Rezoning Transportation Analysis

Petition Number: 2020-134

From: Robyn Byers, PhD
Robyn.Byers@charlottenc.gov
704-336-7404

Reviewer: Kevin Parker, PE
Kevin.Parker@charlottenc.gov
704-432-6511

RZ-1.0

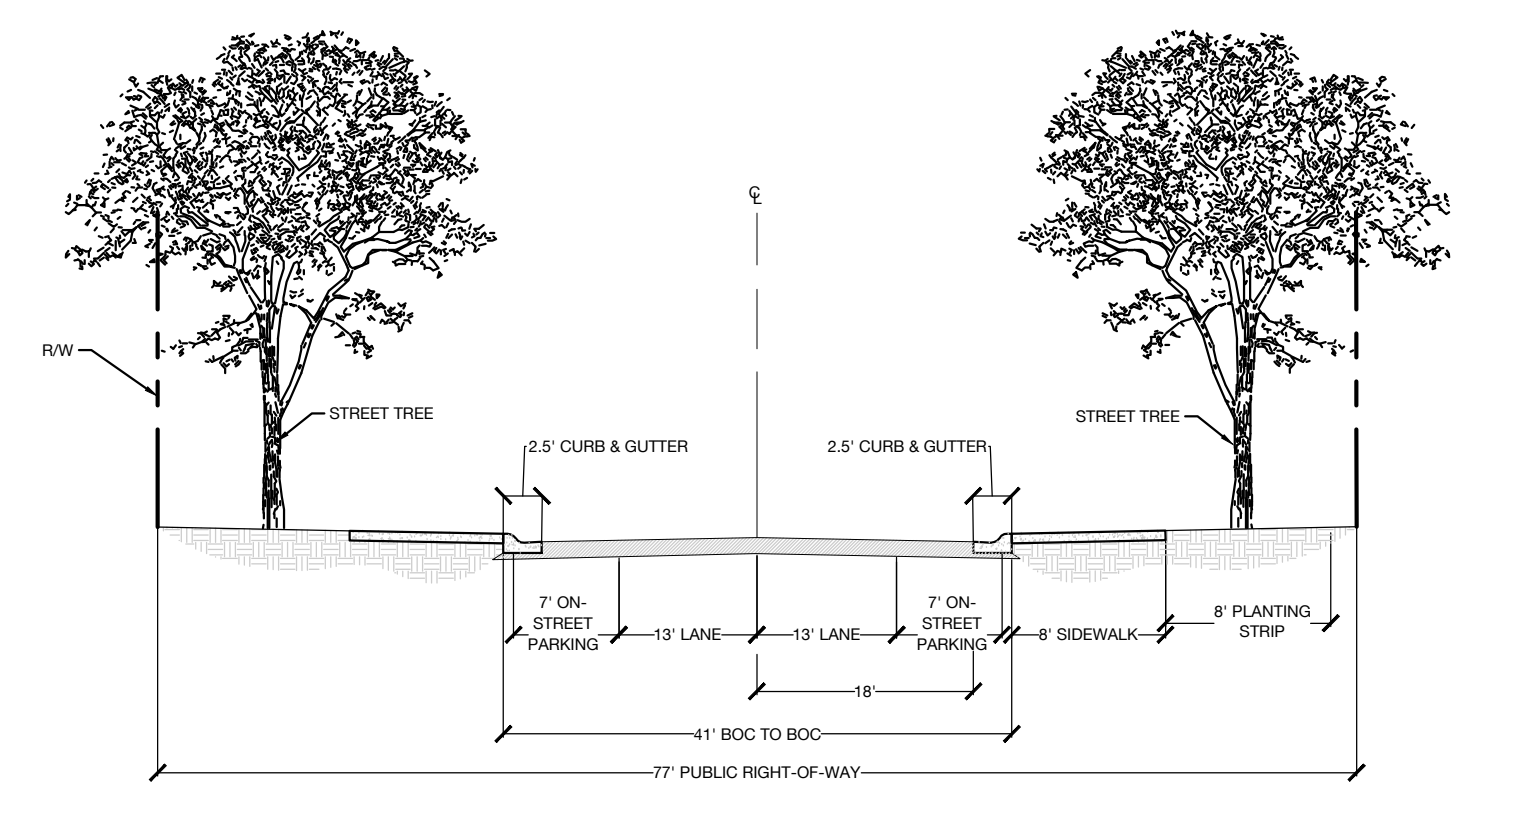
1. Curb line:

- a. ~~Mt. Holly Road:~~ The future location of curb and gutter will be located 33-feet from centerline to the back of curb.
- b. ~~Rhyme Road:~~ The location of curb and gutter will be located 19-feet from centerline to the back of curb.

Label and dimension the curb and gutter from the centerline for each road.

3. Right-of-Way Dedication:

- a. ~~Mt. Holly Road:~~ Revise the site plan and conditional note(s) to commit to dedicate 55-feet of right-of-way from the road centerline. ~~Update as a result from 11-16-2020 Site Plan:~~ Dedicate as much ROW as possible without encroaching into the Railroad ROW.
- b. ~~Rhyne Road:~~ Revise the site plan and conditional note(s) to commit to dedicate 41-feet of right-of-way from the road centerline. ~~Update as a result from 11-16-2020 Site Plan:~~ 40-feet of ROW dedication is acceptable.

The site plan should label and dimension the right-of-way from the road centerline.

~~Update as a result of the 11-16-2020 Site Plan:~~ Add a conditional note stating that the 12-foot MUP will be extended across the railroad and connected to the bicycle pedestrian infrastructure constructed as a part of the Mount Holly-Sonoma Valley/Rhyne Road Intersection Improvement Project. This MUP connection will coincide with the intersection improvement project and will be coordinated with NCDOT.

5. ~~Rescinded.~~ Revise the site plan to show, label, and dimension the center lane median, on Rhyne Road, in front of Site Entrance 2, that will direct the right-in right-out movement(s). Also, include the commitment to construct this center lane median in the conditional notes.

~~Comment Addressed in the 12-15-2020 Site Plan:~~ Included a \$35,000 contribution towards this MUP when the intersection improvement occurs.
